Application No: AL/96/20/HH  
Site Address: 10 Woodgate Close Woodgate Aldingbourne PO20 3TA  
Description of works: Installation of front facing roof lights

Thank you for your internet representation made on 19th January 2021 which has been recorded as an objection with the comments as follows:

proposed west elevation
SCALE 1:100

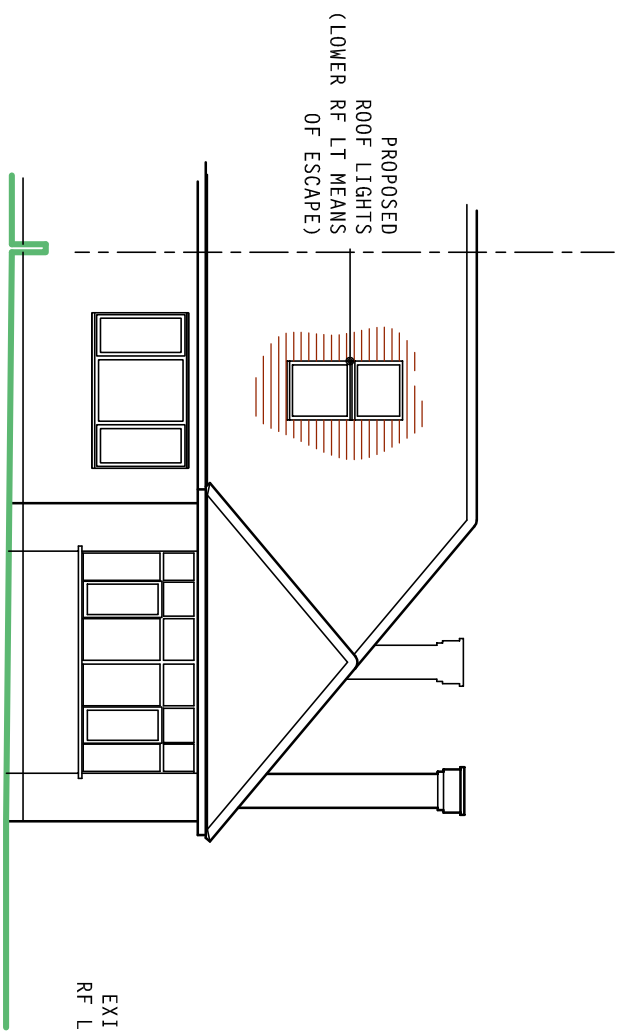
The big double window is too big and out of character with all other conversions where they are all single. From experience of the bungalow behind us who have singles we have there lights shining into our lounge the same will happen, to our bedroom. It should be single. I must stress I have nothing against it in principle just trying to get the best for everyone.  
it needs to be single. I have nothing against it in principle.
